**KIRKLEES METROPOLITAN COUNCIL
INVESTMENT & REGENERATION SERVICE**

**DELEGATED DECISION TO DETERMINE APPLICATIONS FOR
CONSENT, AGREEMENT OR APPROVAL REQUIRED BY CONDITION**

Reference No:	2025/44/91054/W
Site Address:	land south of, Swallow Lane, Golcar, Huddersfield, HD7 4NB
Description:	Discharge of details reserved by condition 23 (secure cycle parking) on previous permission 2023/92749 for variation of condition 2 (plans and specifications) on previous permission 2020/94096 for erection of 21 dwellings and associated works
Recommending Officer:	Liz Chippendale

location STANDARD DETAILS			
title Bike Rack - Fence Mounted			
scale 1:20	drawn by JHY	date MAR 2025	
drawing no. JHY-SDL-0005		rev -

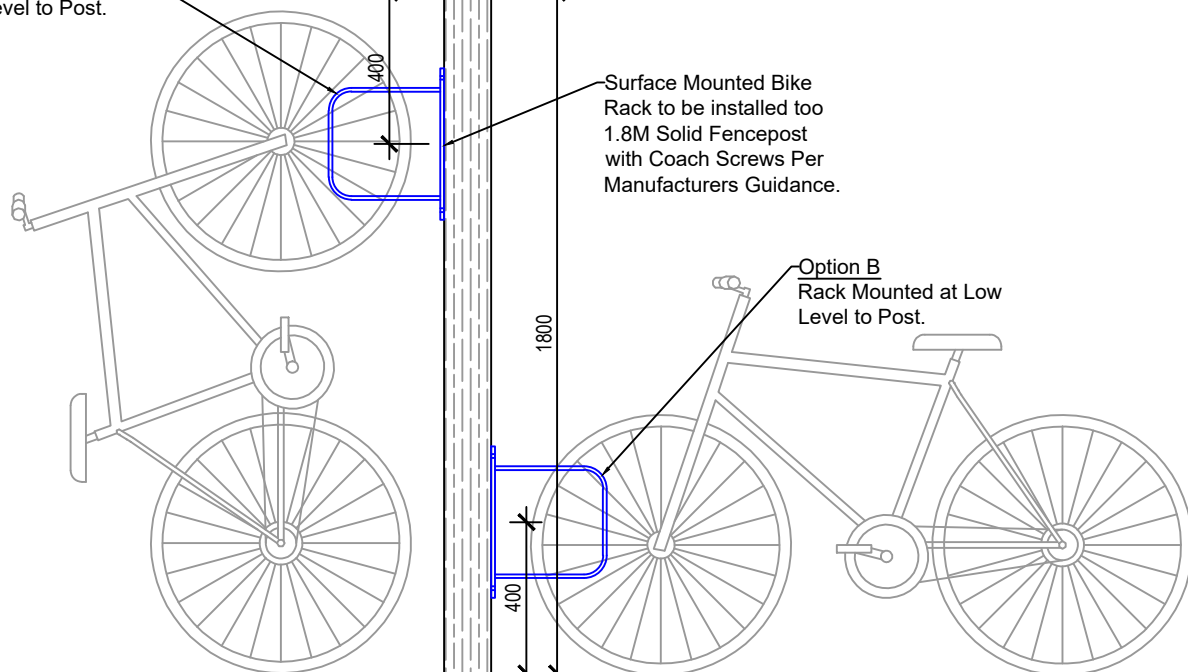
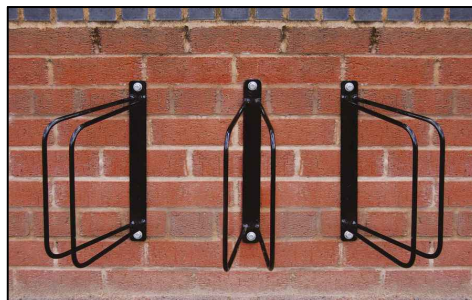
The proposed installation of fence mounted bike racks for those dwellings without a garage is not considered acceptable.

The medium or long-term storage of bikes via an external rack would not protect the bike from the elements, which will lead to damage and deterioration of the bike (particularly if an electric bike). Furthermore, the proposed rack would have limited crime mitigation value, with the degree of protection limited to a chain or similar.

Due to the above, it is concluded that the rack would not provide a convenient or welcoming means of storing a bike and therefore would not achieve the condition's objective of encouraging travel by alternative means.
